Our Ref: EP/178/18/CLE

Development Lawful development certificate for the existing use of ancillary building as garden room.

Location Garden House Rear of 8 Sea Road East Preston

| <b>DETAIL:</b> EXISTING FLOOR<br>PLAN & ELEVATIONS<br>GARDEN HOUSE                                                                                 |

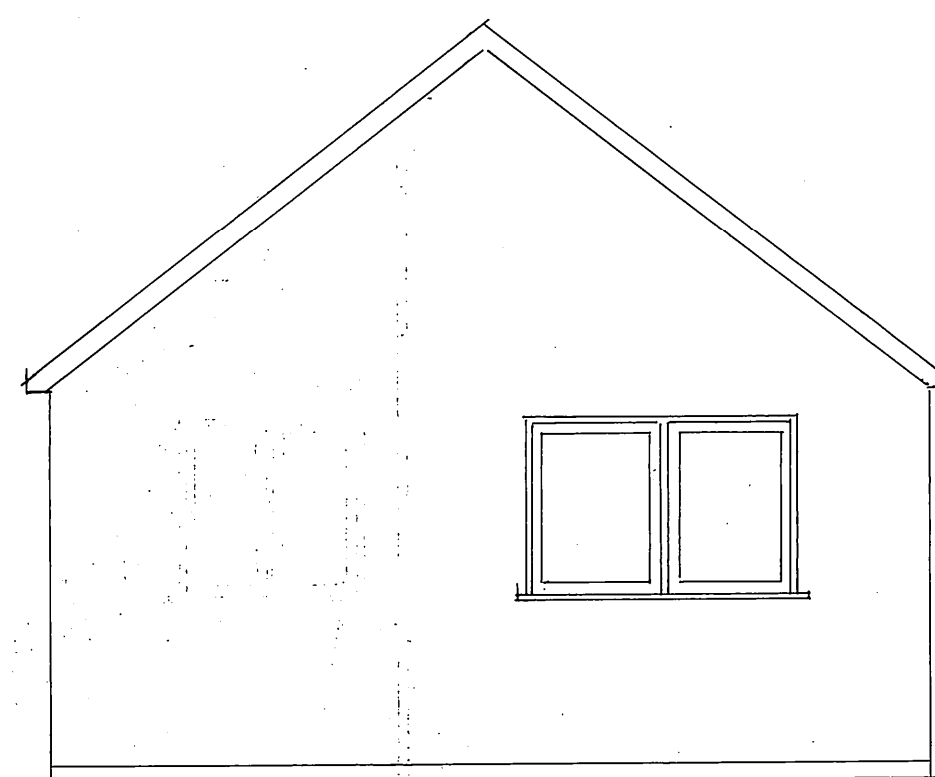
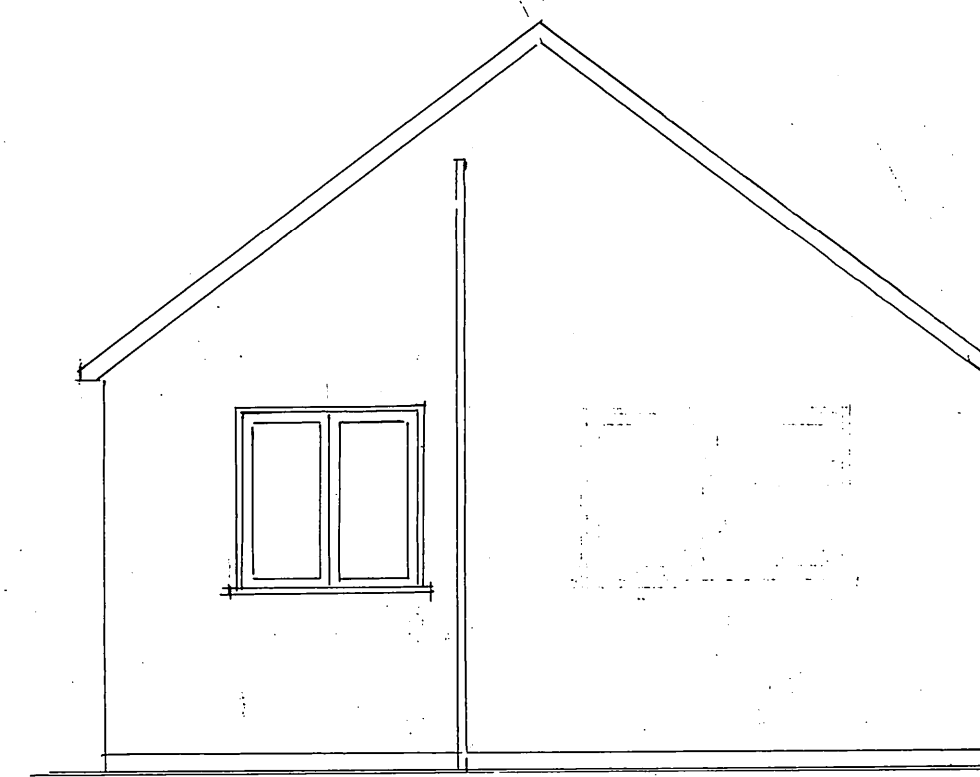
The existing east and west elevations have been mislabelled. Please amend accordingly.
